STATE OF NORTH CAROLINA
DEPARTMENT OF TRANSPORTATION

Subject: **Application for the Modification to the Section 404 Individual Permit and Section 401 Water Quality Certification** for US 501 from NC 49 in Roxboro to SR 1602 (Jesse Banks Road) in Person County, Division 5. Federal Aid Project No. STP-501(11), WBS Element No. 34406.2.3, TIP No. R-2241A.

Reference: Section 404 Individual Permit, issued June 6, 2012 USACE Action ID 2009-00439
Section 401 Individual Water Quality Certification, April 5, 2012, NCDENR-DWQ
Water Quality Certification Project No. 20120073

This permit modification request is for revisions to the permit drawings and plan sheets and additional impacts to streams for items that were accidentally left off the drawings from previous meetings and a revision to Utility Site 1. Included with the permit modification is this cover letter, revised Stormwater management plan and revised permit drawings 3, 3a, 4, 5, 16, 17, 27, 28, 35, 36, 37, 38, 39, 40, 45, 46, 47, 48 of 48, revised Utility Site 1 drawings and revised plan sheets 4, 8, 15, 19, 20 and 22.

Revised 7/5/12
 Permit Drawing
 Sheet 37 of 48

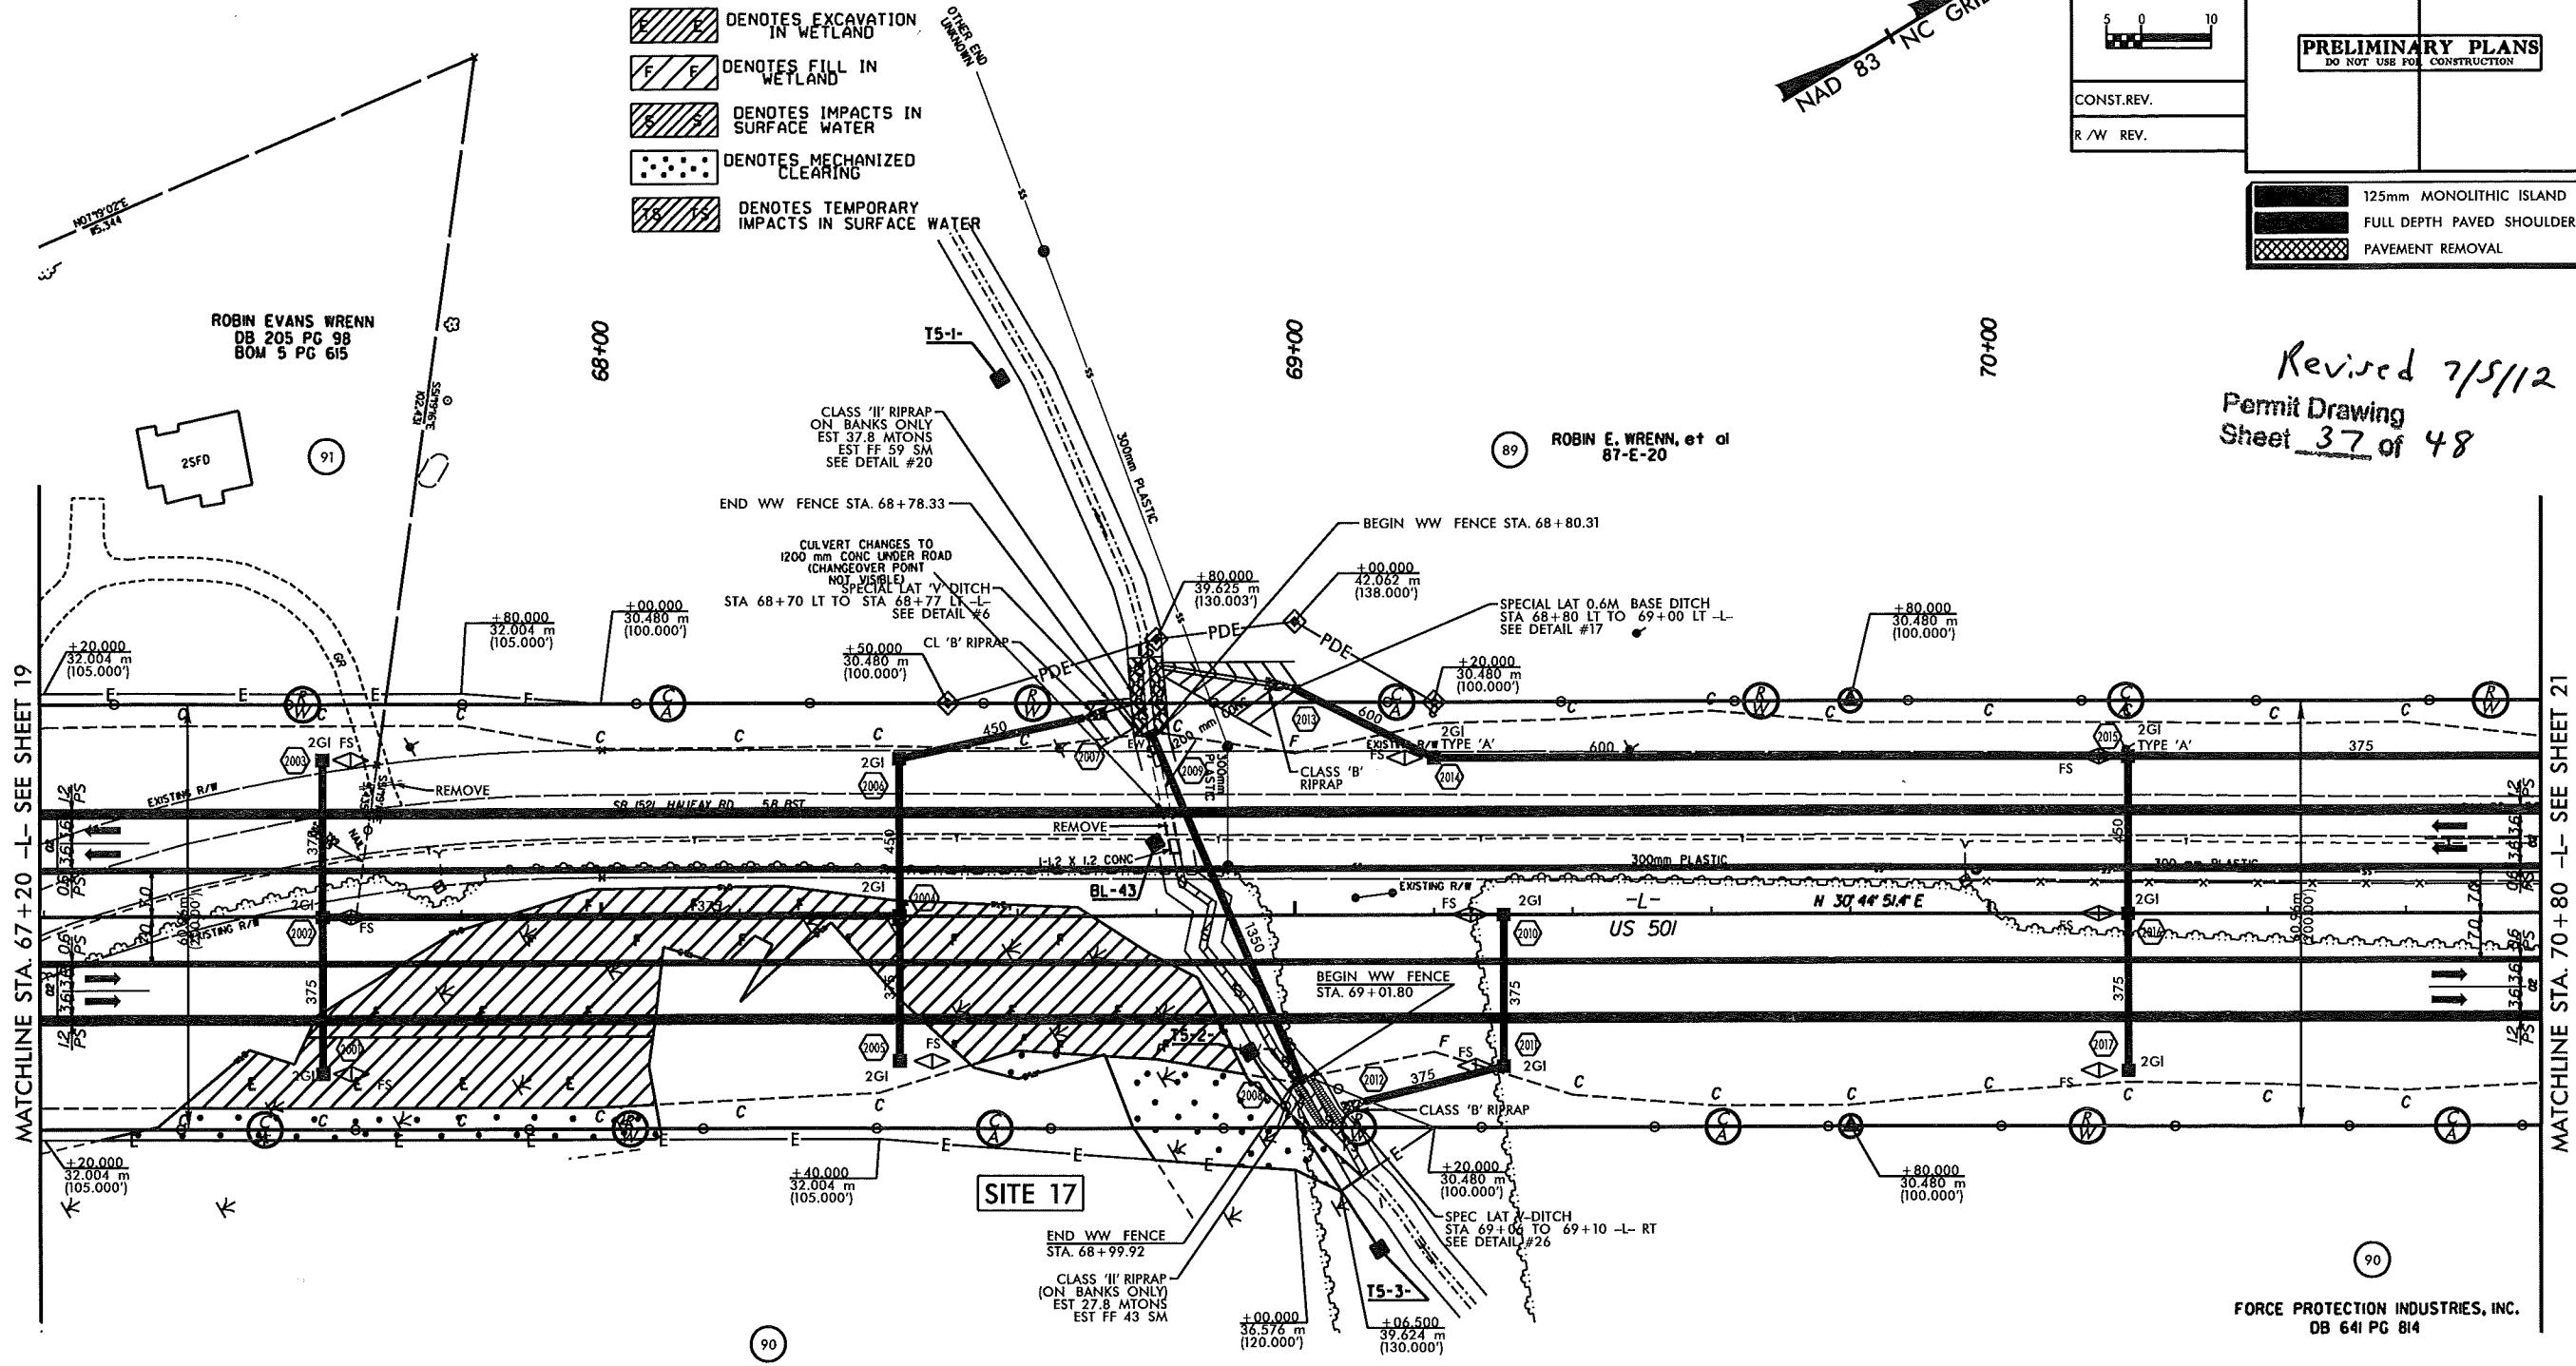
Site 17, Permit Drawing 37 of 48 (Plan Sheet 20)

-Rip rap on both streambanks at the pipe inlet has been extended to go past the outlet of the adjacent 375 mm pipe structure. This will provide long-term stability of the streambank at this location. This has resulted in the following change of impacts:

- decrease of 2 linear feet of existing permanent channel impacts due to a recalculation of fill impacts, increase of 31 linear feet of existing permanent channel impacts due to streambank stabilization and a decrease of 39 linear feet of existing temporary channel impacts. The stream impact summary sheet has been revised to reflect this change.
- Total streambank stabilization impacts now total 67 feet and temporary impacts total 23 feet.

Revised 7/5/12
 Permit Drawing
 Sheet 39 of 48

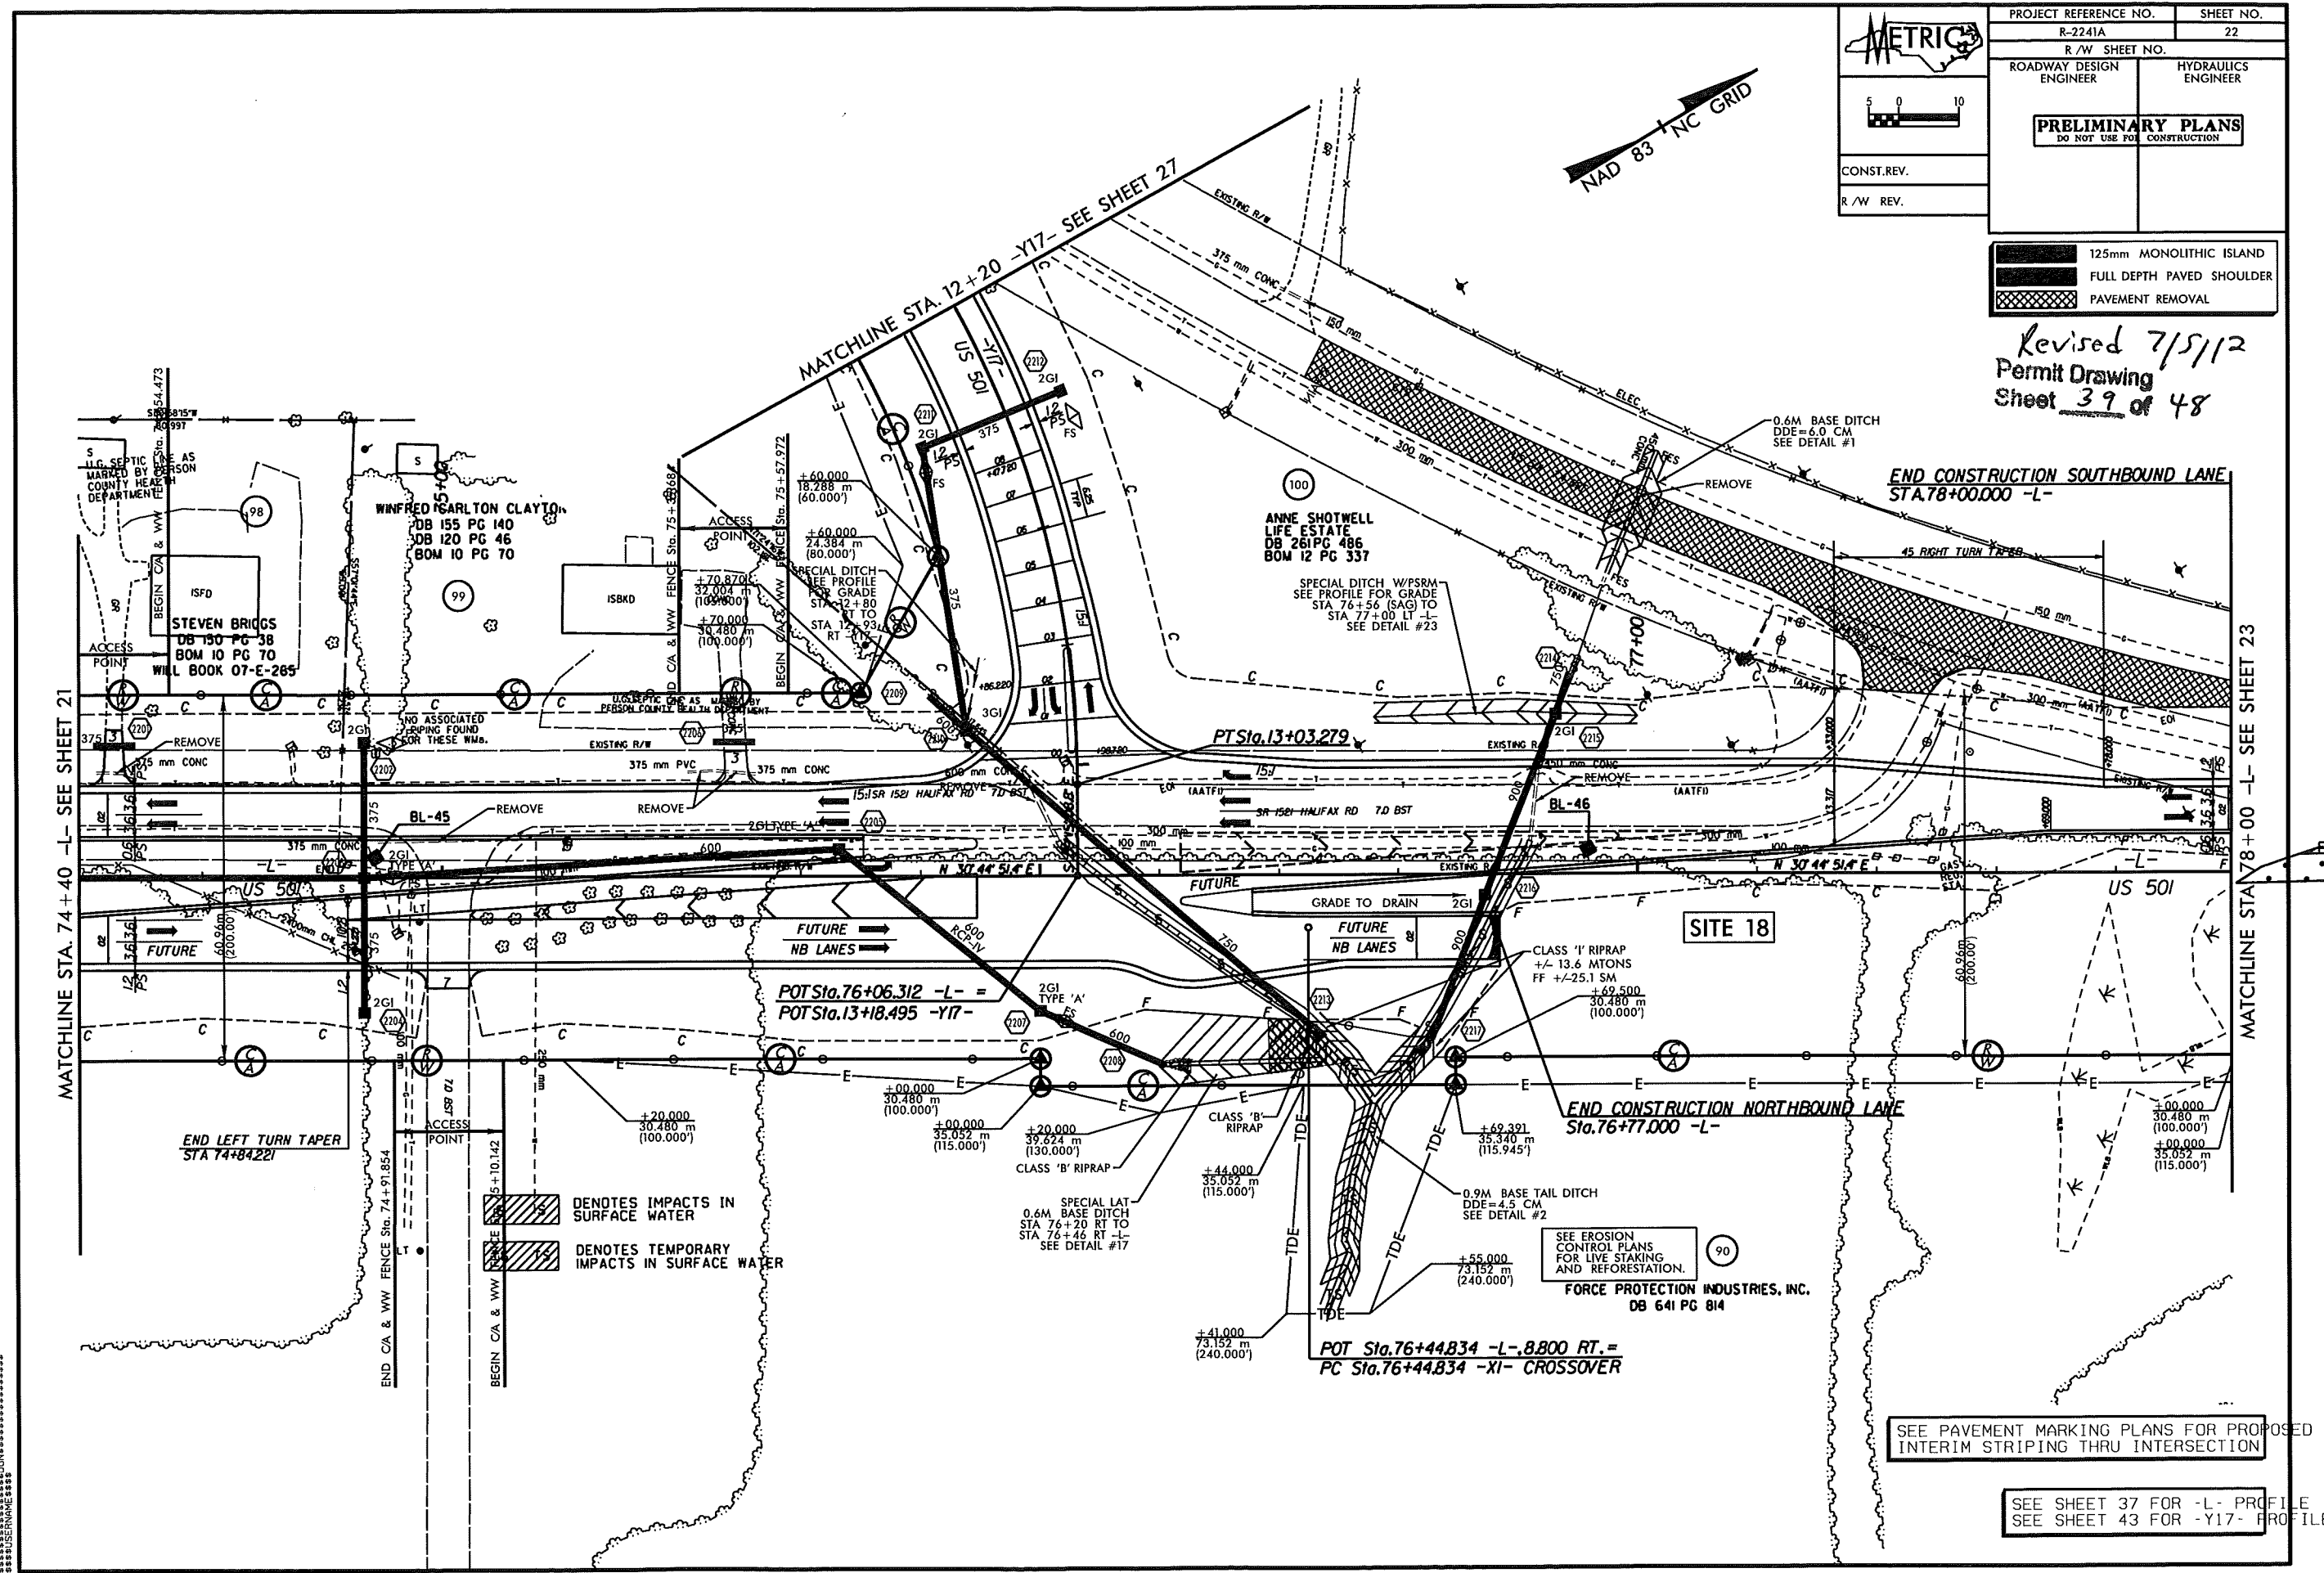
Site 18, Permit Drawing 39 of 48 (Plan Sheet 22)

-Class B rip rap depicted at tail end of the Special Lateral 0.6 m Base Ditch has been slightly extended to the edge of the flow line of the stream channel. Additionally, Class I rip rap pads have been added in the flow line of the channel at the outlet of the 750 mm and 900 mm pipe structures. The rip rap pads will be countersunk below the flow line of the channel to prevent formation of scour washes in the downstream channel. This has resulted in the following change of impacts:

- decrease of 10 linear feet of existing permanent channel impacts due to a recalculation of fill impacts, increase of 32 linear feet of existing permanent channel impacts due to streambank stabilization and a decrease of 22 linear feet of existing temporary channel impacts. The stream impact summary sheet has been revised to reflect this change.
- Total streambank stabilization impacts now total 42 feet and temporary impacts total 181 feet.
